From: [PMO](#)
To: [Wylfa Newydd](#)
Subject: IACC Deadline 2 Submission : First Written Questions (email 1 of 4)
Date: 04 December 2018 20:12:14
Attachments: [image001.png](#)
[image002.png](#)
[image003.png](#)
[IACC Response to ExA First Round of Written Questions.pdf](#)
[Written Questions Annex 1.zip](#)

7.	Landscape and Visual
-----------	-----------------------------

VIEWPOINT 11 WINTER

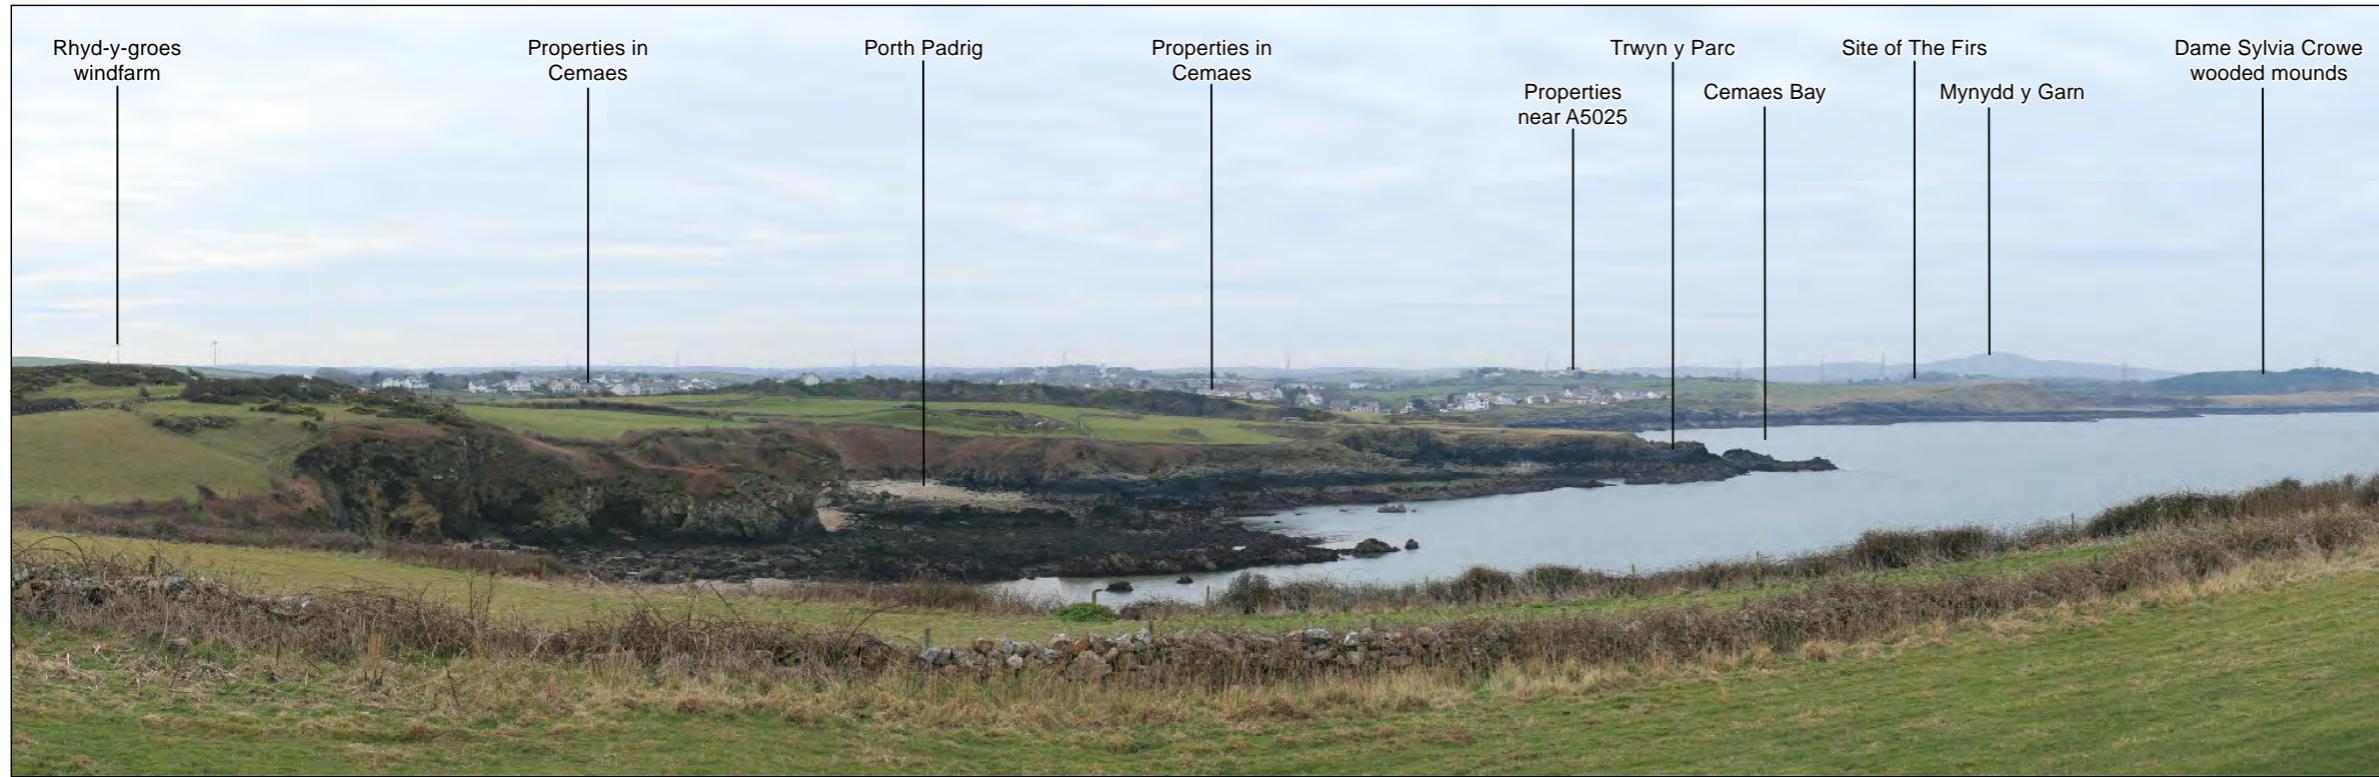
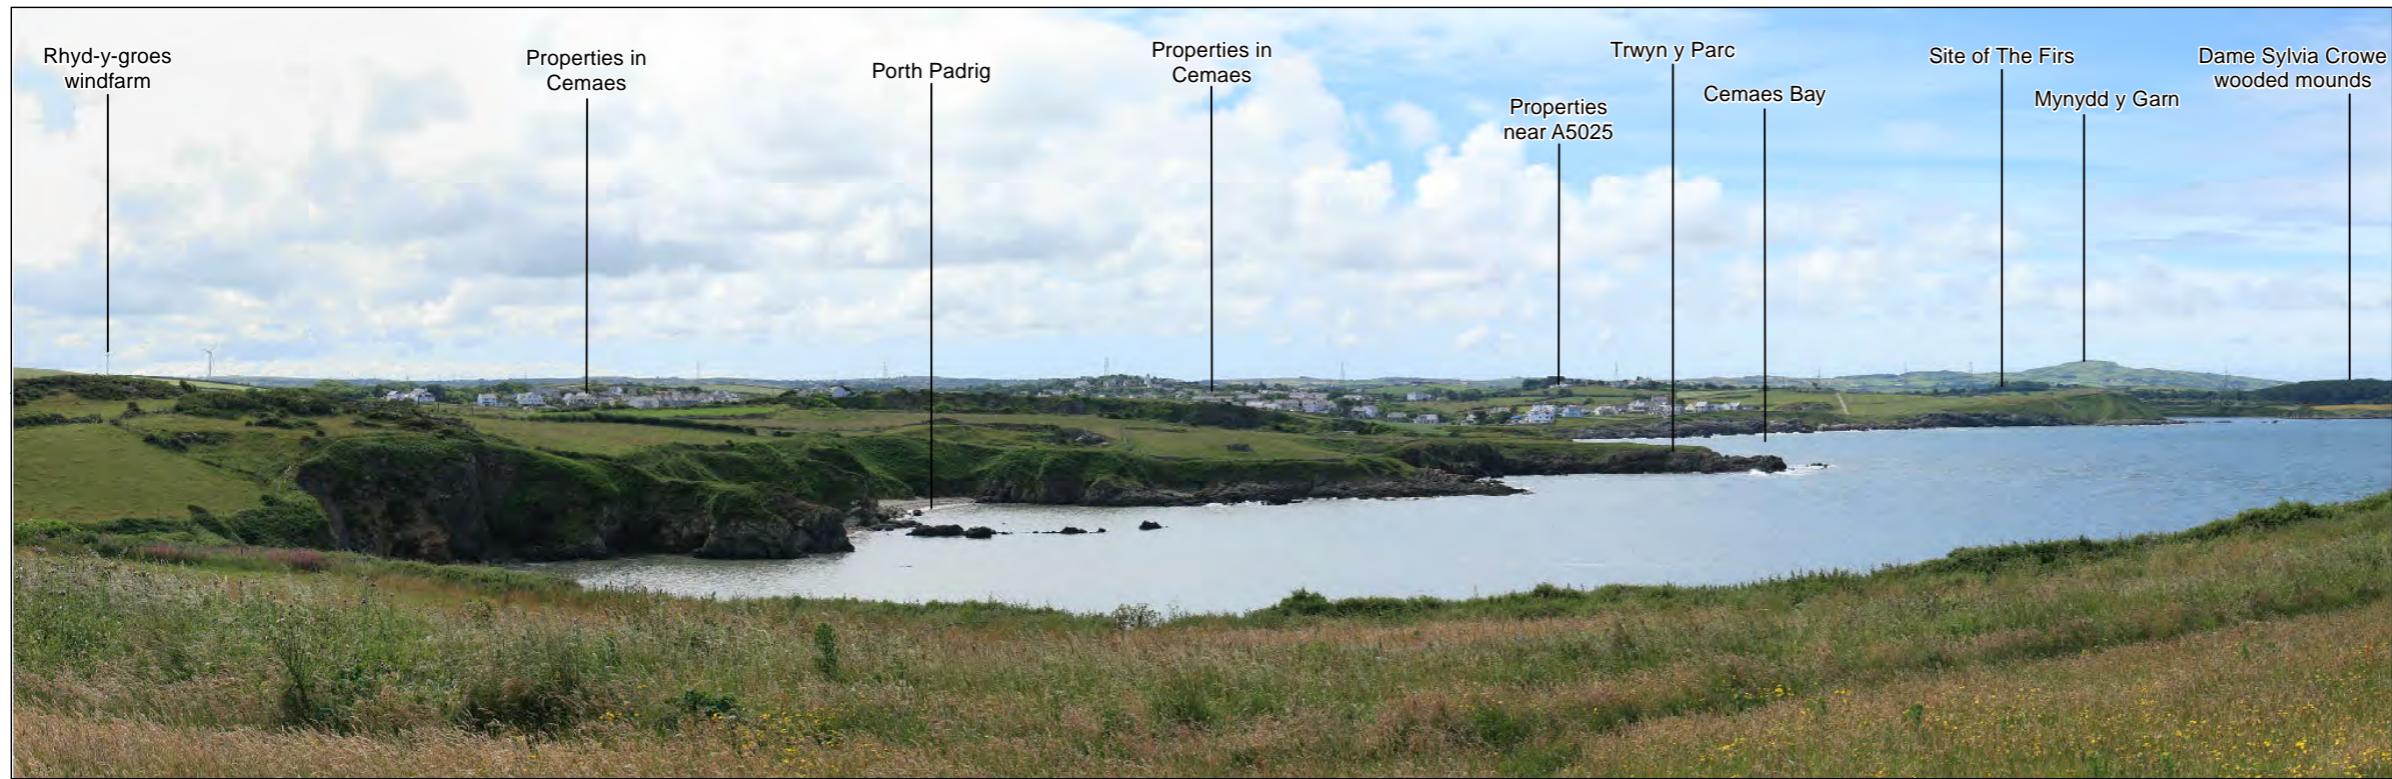
Reference	Respondent:	Location:	Question:
			enhance existing field boundaries commencing at the Site Preparation and Clearance. IACC is concerned that the potential for using these perimeters, which in some sections e.g. opposite Tregele, have a width over 100m, has not been fully utilised. IACC notes that the Wales Coast Path temporary diversion will be routed along this perimeter and its treatment will therefore have an impact upon the attractiveness of this important tourism asset throughout the construction period. The undisturbed perimeter also provides important opportunities for the establishment of localised screen planting early in the construction period that could reduce adverse visual effects upon residential and recreational visual receptors later in the construction period and into the operation period. This issue is related to the absence of a comprehensive inventory of field boundaries within the WNDA site as noted in the response to Q7.0.1(d). IACC recommends the submission of drawings showing the field boundaries to be retained and enhanced in the perimeter area; the location and type of new field boundaries; the detailed alignment of the temporary diversion of the Wales Coast Path and associated location of stiles and gates; and seeding and planting types and locations. IACC acknowledges that visualisations of the Site Campus are provided in the Appendix 1-2 of Volume 3 of the Design and Access Statement [APP-409]. IACC recommends that these are supplemented by photomontage visualisations showing the fully operational Site Campus. Photomontages are to be provided from: • Representative Viewpoint 10: Wylfa Head; • Representative Viewpoint 13: Wales Coast Path at Penrhyn; and • Representative Viewpoint 11: Porth Llanbadrig.

Reference	Respondent:	Location:	Question:
			These three representative viewpoints have been selected as visual receptors at these locations will have open, close and middle distance views that will not benefit from screening subsequent to the formation of Mounds A-E. IACC recommends that all planting is maintained for the full length of the construction period. As set out in the Lighting LIR, IACC is not satisfied with the good practice measure concerning control of light spill to reduce nuisance on communities being undertaken "<i>as far as practicable</i>". Hence, a detailed lighting design is required to be submitted to and approved by IACC. <u>Operation Period</u> With reference to the assumed growth rates provided in Section 10.4.38 of D10 [APP-129], IACC notes that the assumed woodland planting height of 7m at operation year 15 is at the upper end of the spectrum of woodland planting growth height for the detailed study area. The trees in the community woodland planted on the western edge of Cemaes in 2003 have attained heights of between 5-8m in the 15 years since planting. The comments upon the measures associated with lighting set out in the construction period (and the Lighting LIR) continue to apply in the operation period. IACC recommends that the planting maintenance is continued throughout the operation period and is not restricted to five years. IACC acknowledges that the composition of the maintenance plan will need to reflect the decrease in the extent of the maintenance activities after five years.
